**Rezoning Transportation Analysis**  
**Petition Number: Insert Zoning Petition #2021-214**  
*General Location Identifier: 11123345*

<b>Revision Log:</b>	<b>Date</b>	<b>Description</b>
	01-21-2022	First Review (AO)

**Transportation Summary**

RZ - 102
 © STIMMEL ASSOCIATES, P.A.

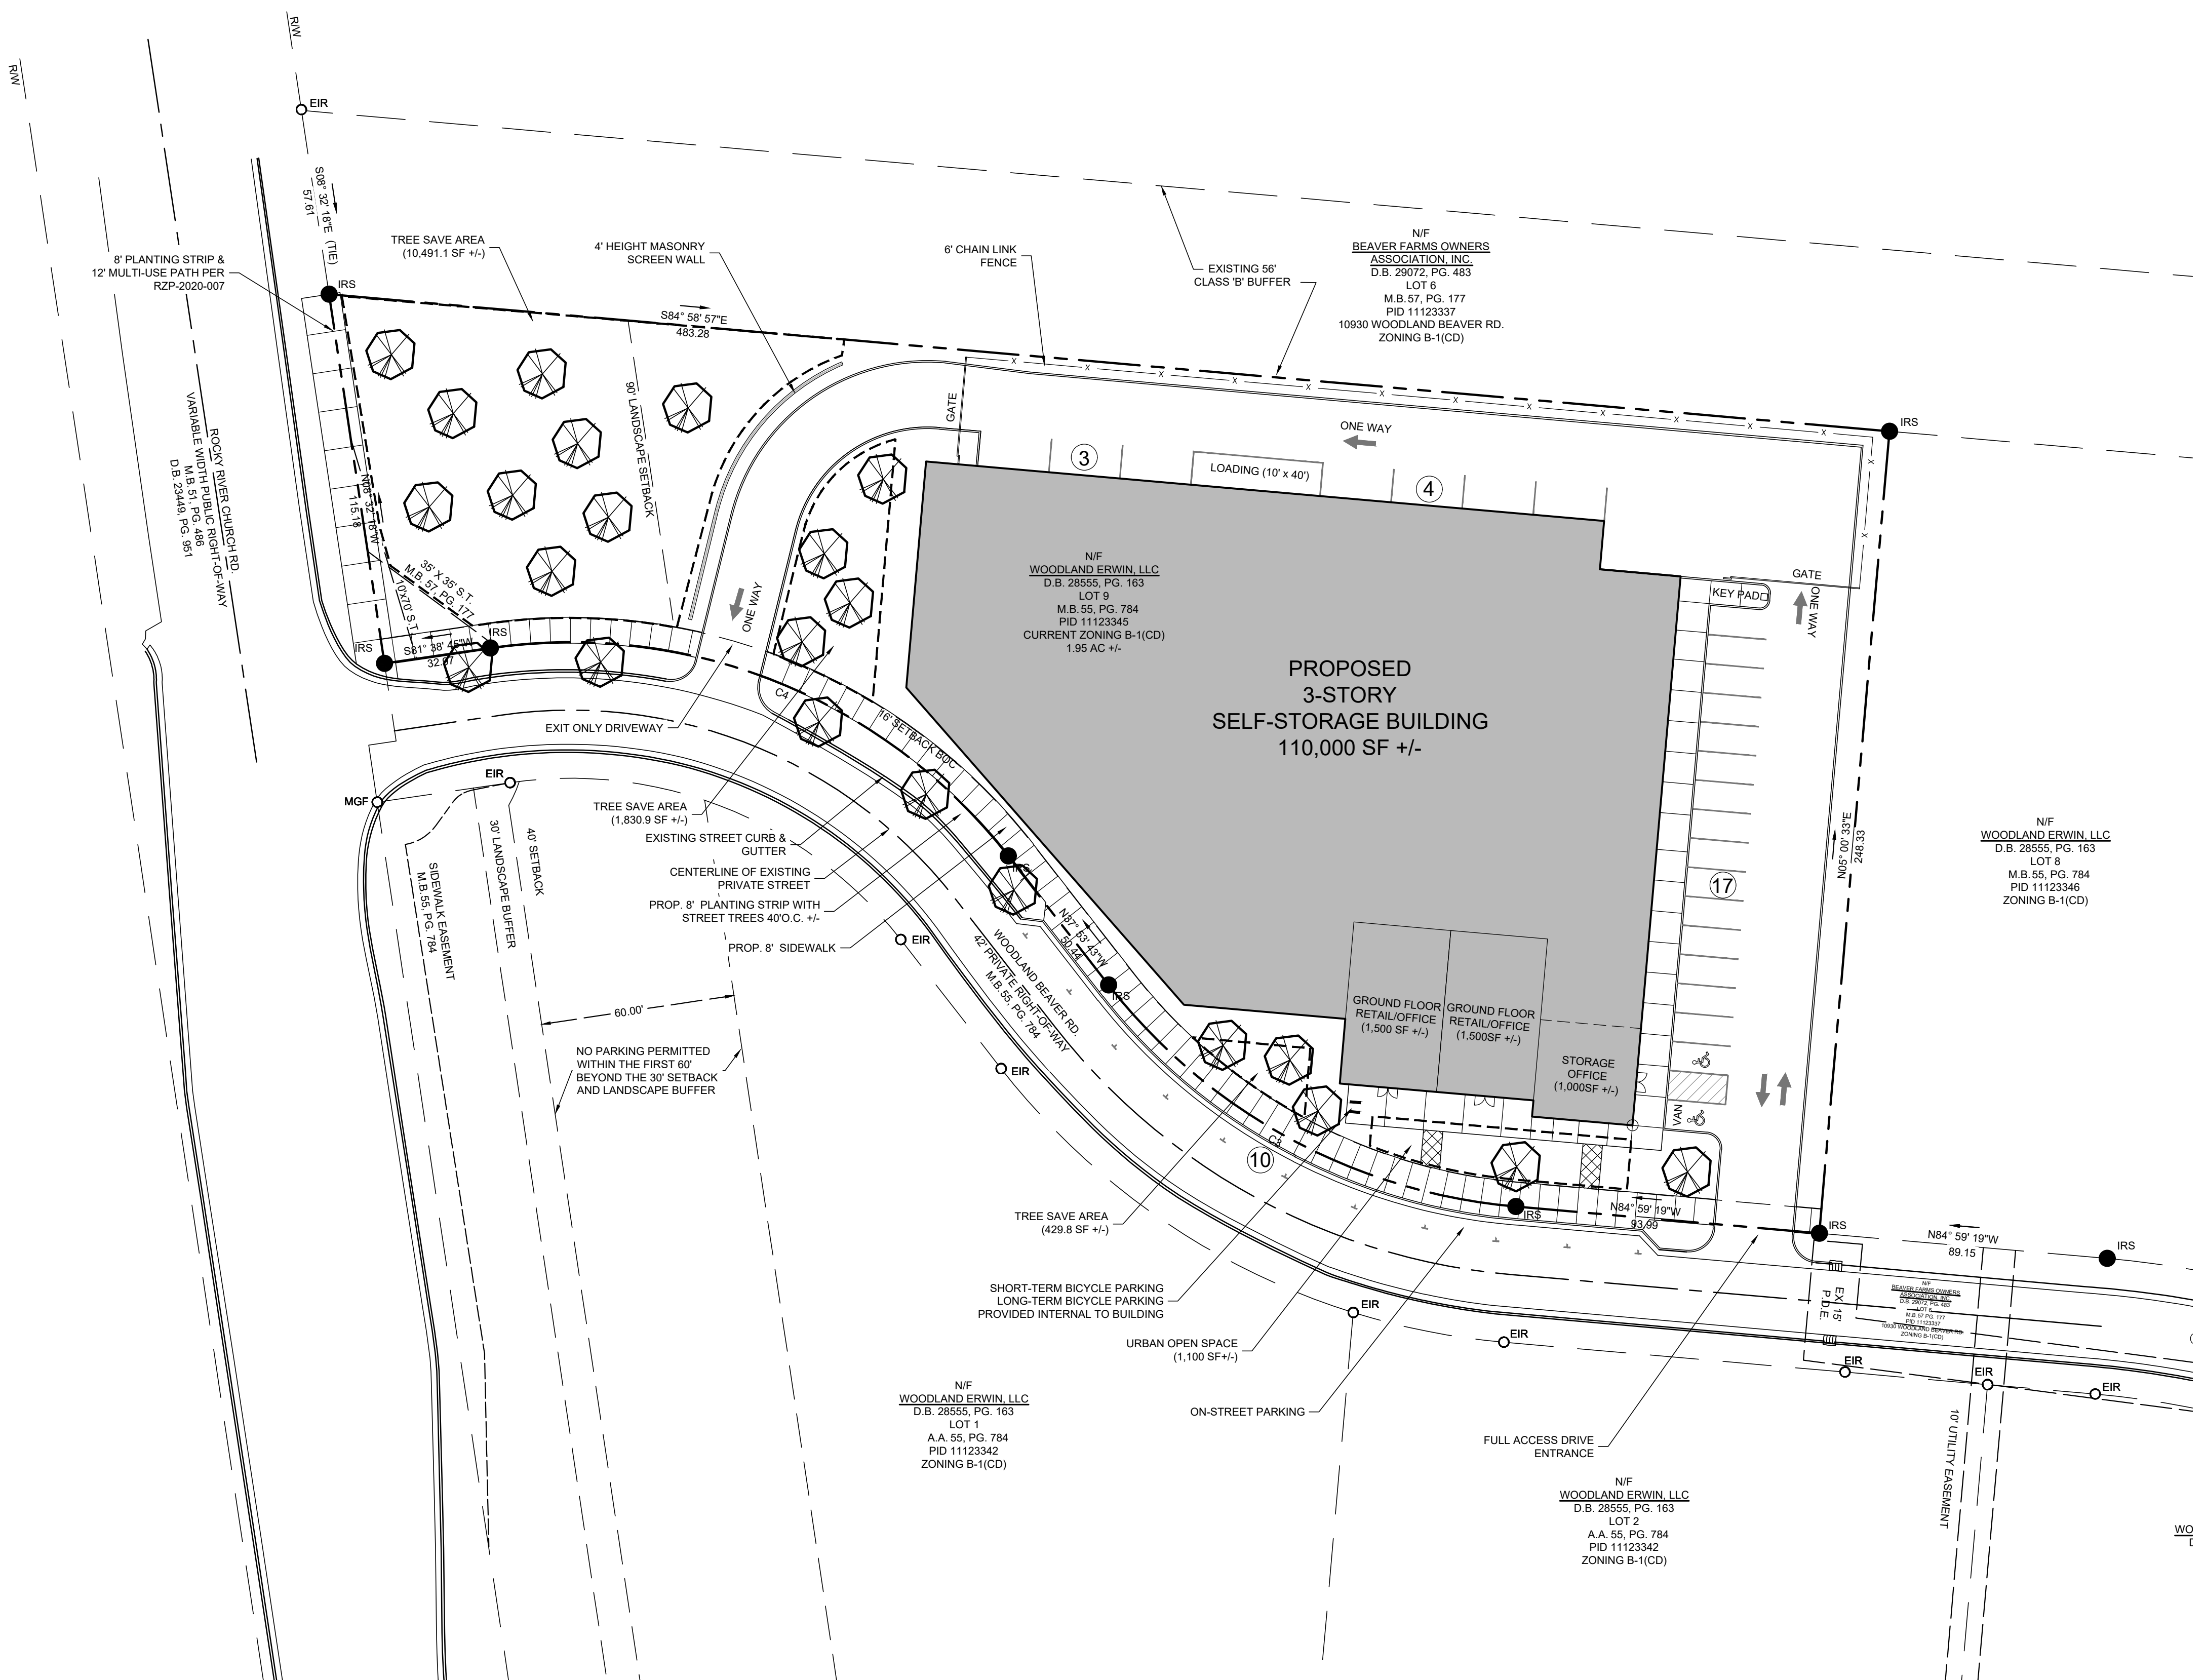
1. **Curbline:** The proposed zoning district has a setback measured from back of the existing or proposed future curblines.
  - a. **Rocky River Road:** Location of curb and gutter is in its existing location.
  - b. **Woodland Beaver Road:** Location of curb and gutter is in its existing location.

Label and dimension the curb and gutter from the centerline for each road on the site plan.

3. Revise site plan to commit to construct an 8-foot planting strip, 12-foot multi-use path along Rocky River Road and an 8-foot planting strip and 8-foot sidewalk on Woodland Beaver Road. Site plan shows call out show multi-use path along Woodland Beaver Road.

The site plan shall label and dimension both items from the back of curb and gutter and road centerline.

4. Revise site plan and conditional notes showing a minimum of 100' of separation from proposed egress access point of Woodland Beaver Road measured from right-of-way line from Rocky River Church Road.

Label and dimension from right-of-way line along Rocky River Church Road.

9. Revise site plan to construct a 12-foot multi-use path on Rocky River Church Road. The site plan shall label and dimension both items from the back of curb and gutter and road centerline. The entire facility must be outside of the right of way and within a public access easement. Add conditional note committing to construction and maintenance of the 12-foot multi-use path on Rocky River Church Road.
